DRB Application No.: 08DRB-70476

Project # 1007267

Project Name: UNITY SUBDIVISION

SUBJECT: Project # 1007267

TREE, PAVER AND ADDITIONAL SIDEWALK DETAIL A-1

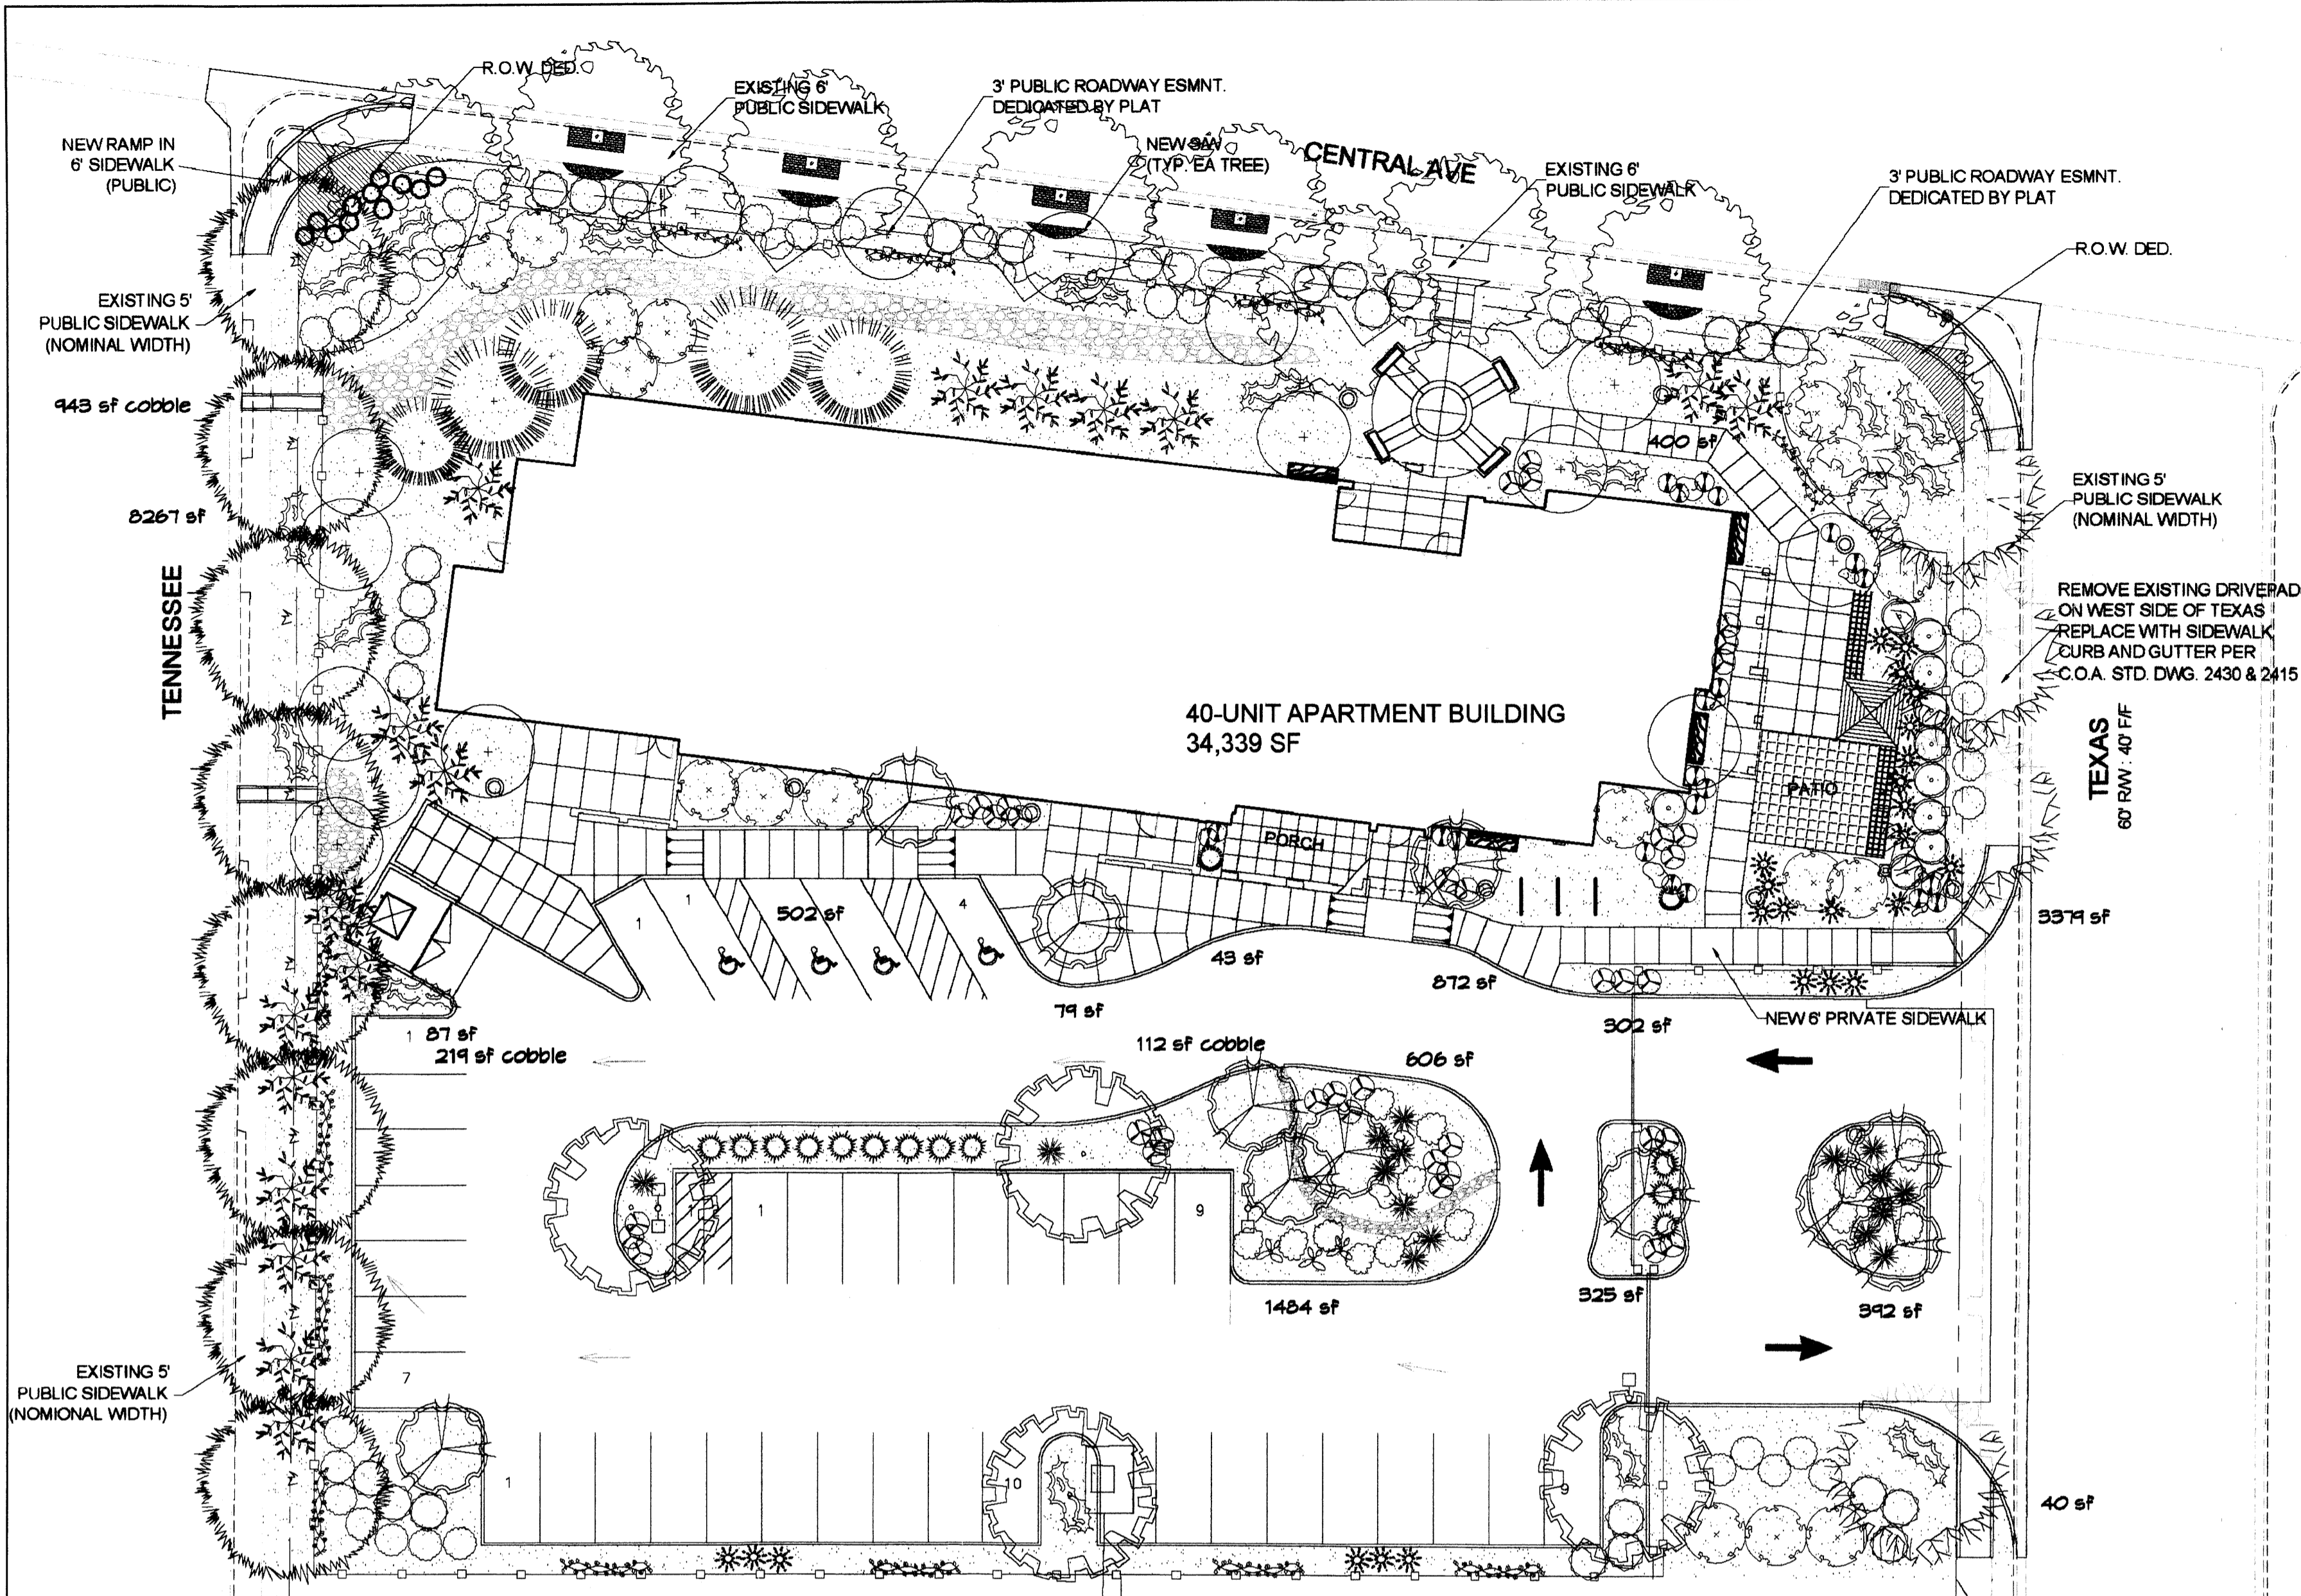
The applicant does have 6 tree grates for the trees along Central to comply with Condition 5a, but one is simply not showing the brick pavers and cutout for tree.
